Response to Submissions and Statement of Commitments

Chatswood Chase Shopping Centre Shopping Centre Expansion and Refurbishment

Submitted to
Willoughby City Council and Minister for Planning
On Behalf of Colonial First State Property Management

September 2007 ■ 07026

Project Number	Drawing Number	Revision
305059	ATP 500	04

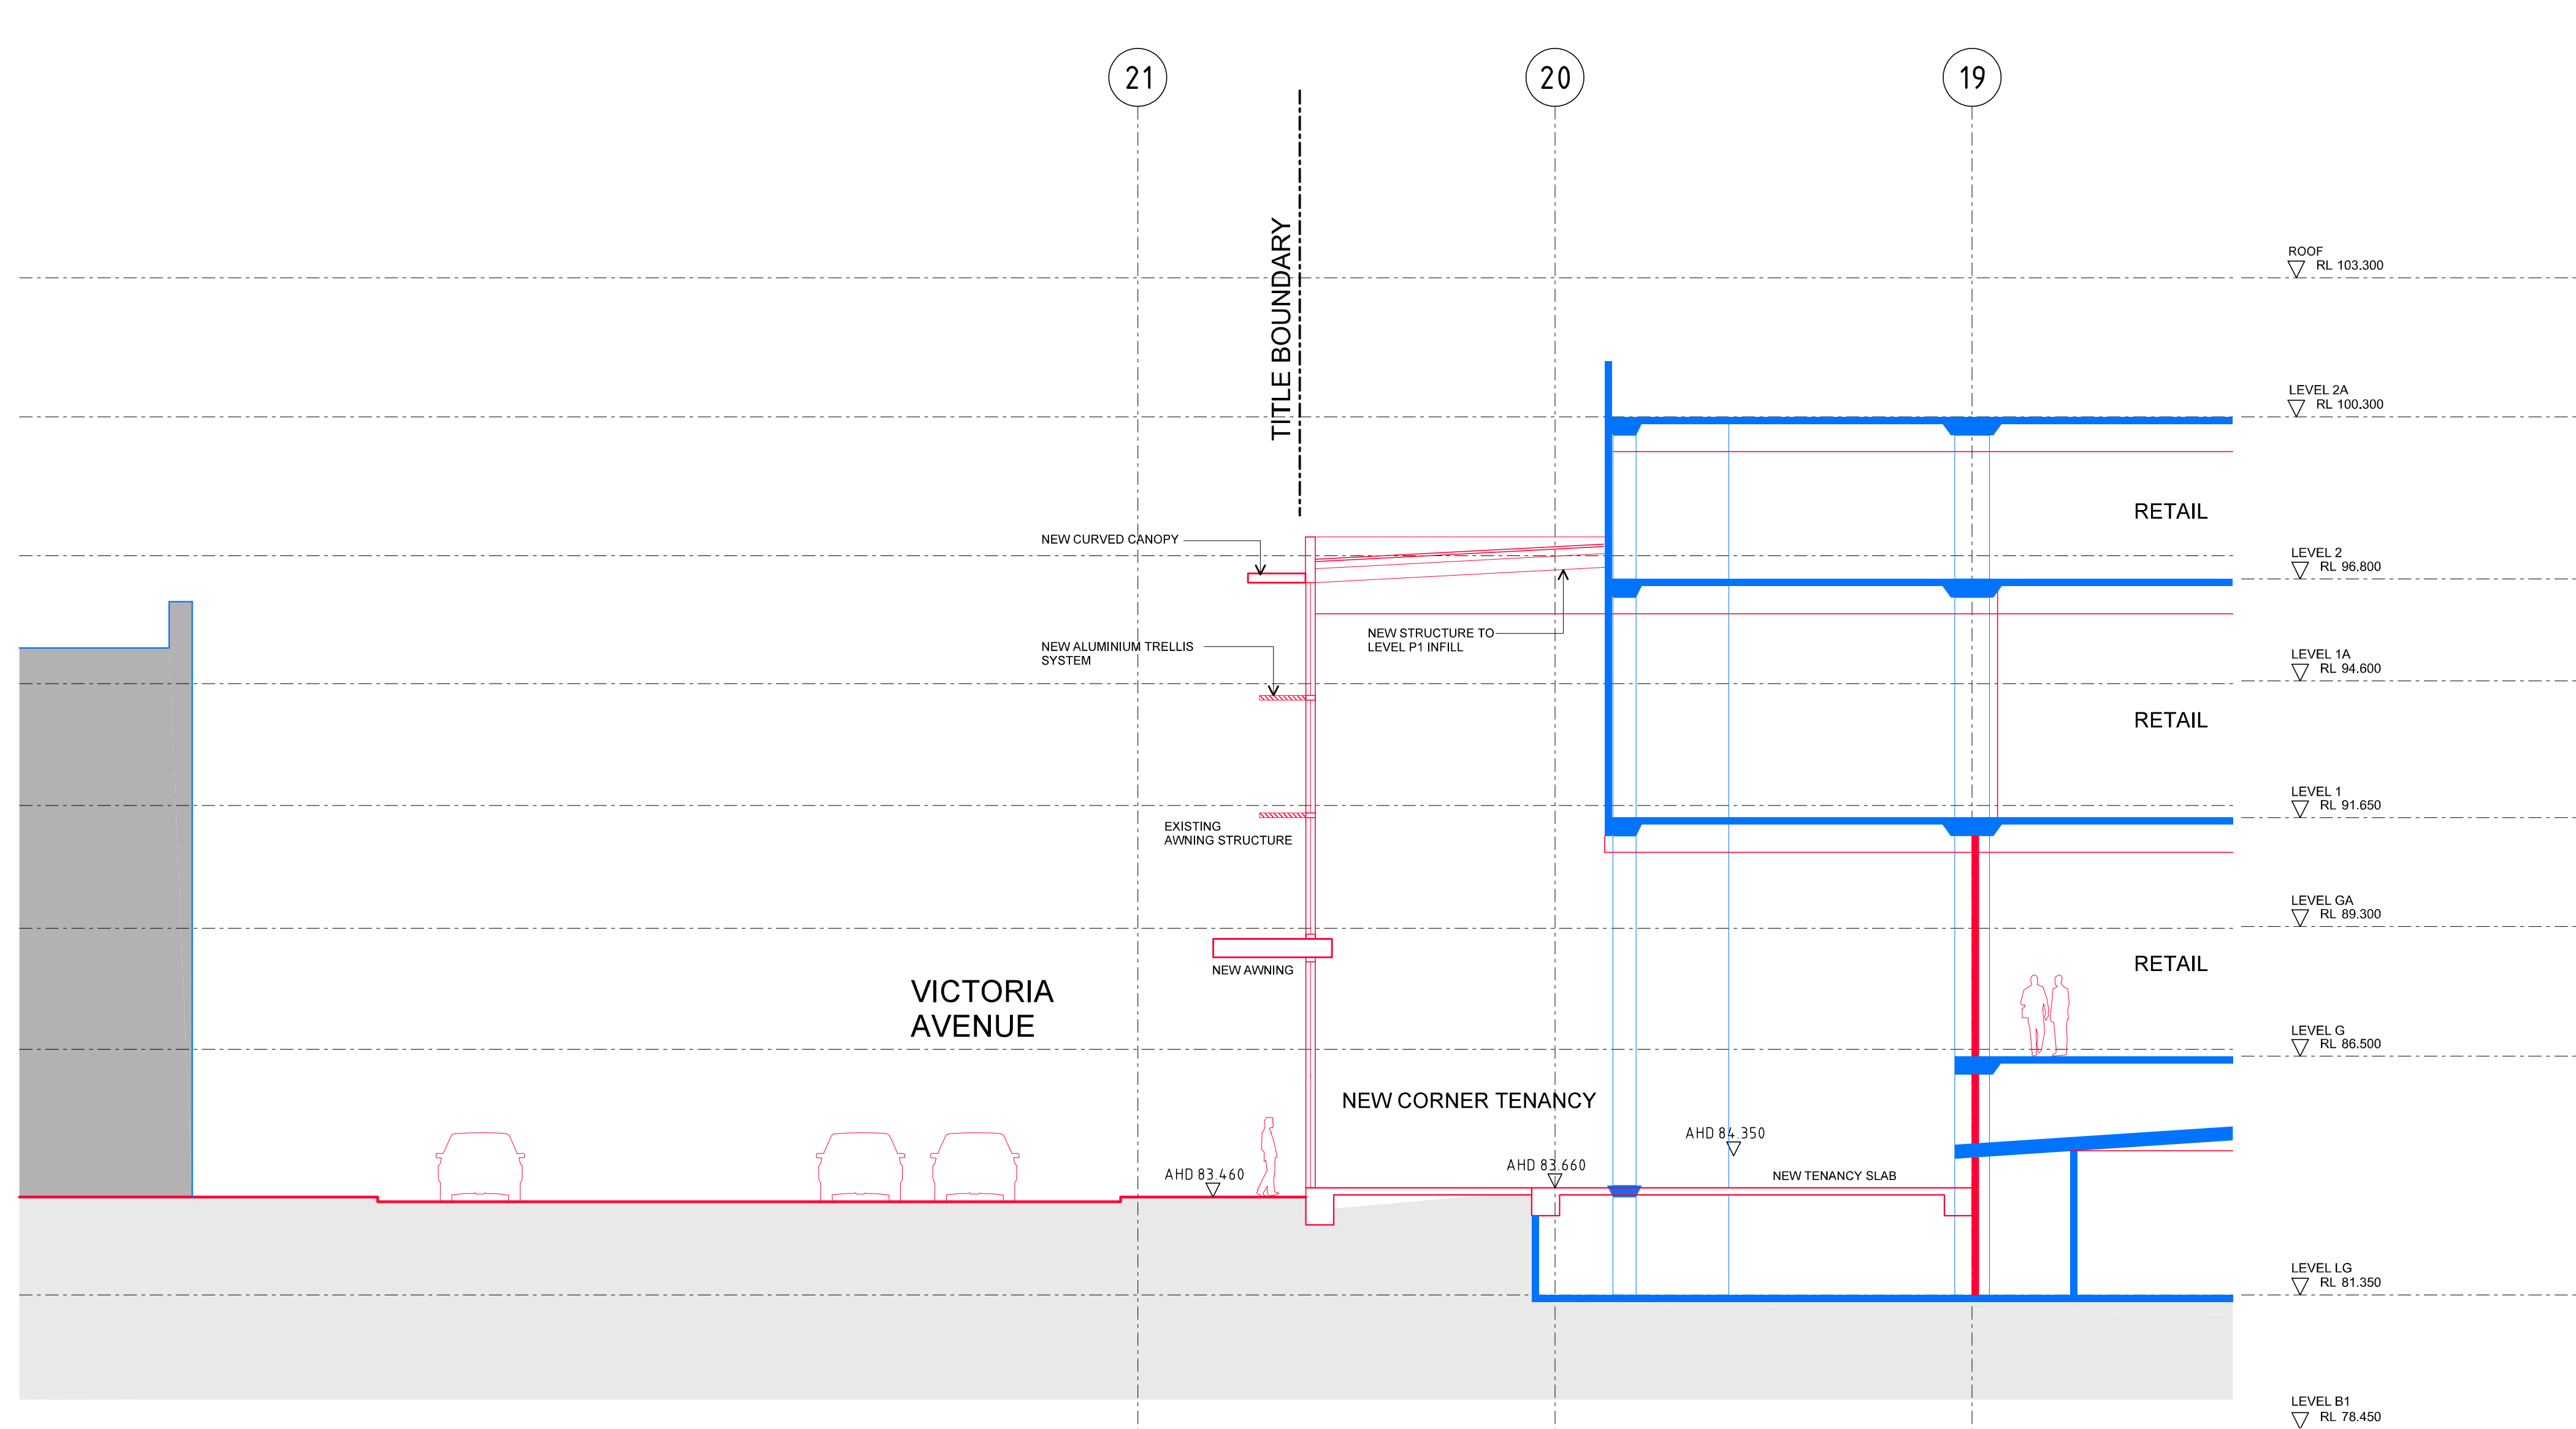
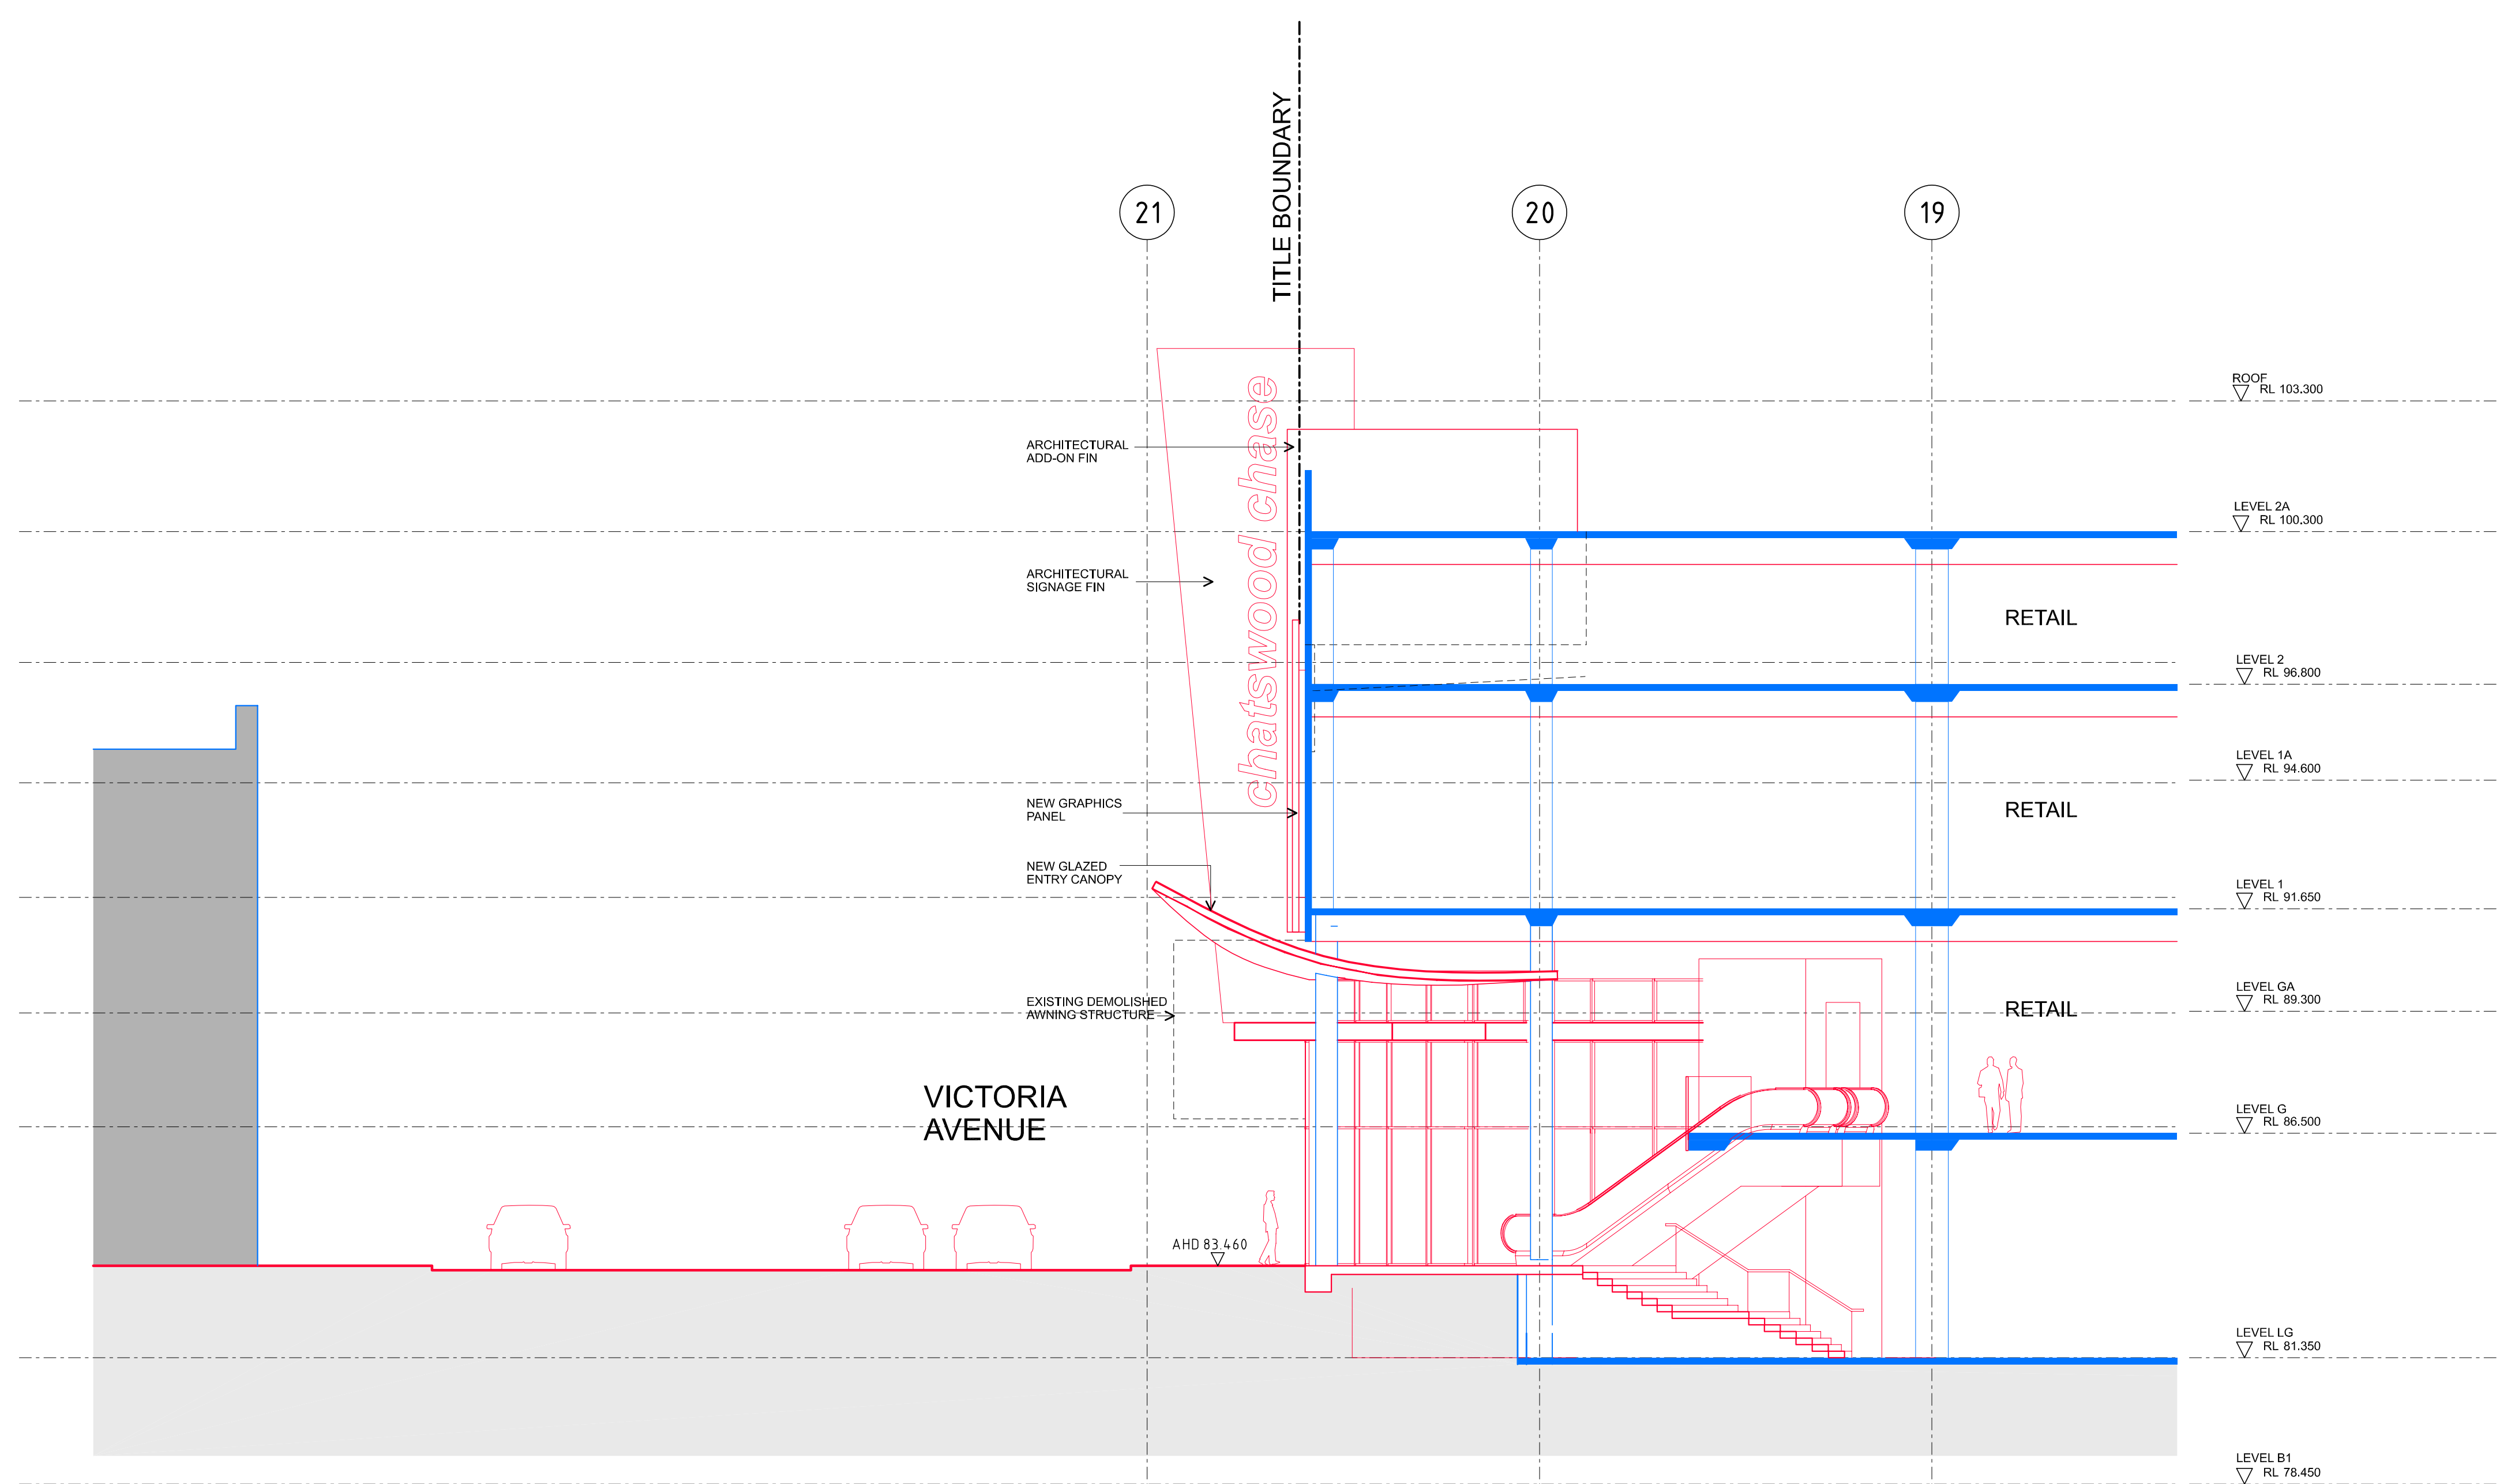
Key Design Change	Reason/Benefit	Drawing Number	Detailed Reference Table (Appendix B) Reference No.
The extensions to various levels in construction zones C and D (located immediately adjacent to 1-3 and 5-7 Havilah Street Properties) will not be constructed any closer to the adjoining properties than the present building line of Level G.	Reduced impact on neighbouring properties.	ATP202, ATP203, ATP204, ATP206, ATP208, ATP501, ATP502	9, 10
Havilah Street Pedestrian Entry			
Proposed roof over Havilah Street entry has been deleted. Tall landscaped screen replaced with 2500mm high hedge screen. Havilah Street Pedestrian Entry will be gated at Havilah Street outside of centre hours.	Improve the amenity, outlook and natural light from the proposed development submitted as part of the EAR in June 2007. New building structure now approximately 4500mm from the joint boundary.	ATP401, ATP502	20, 21
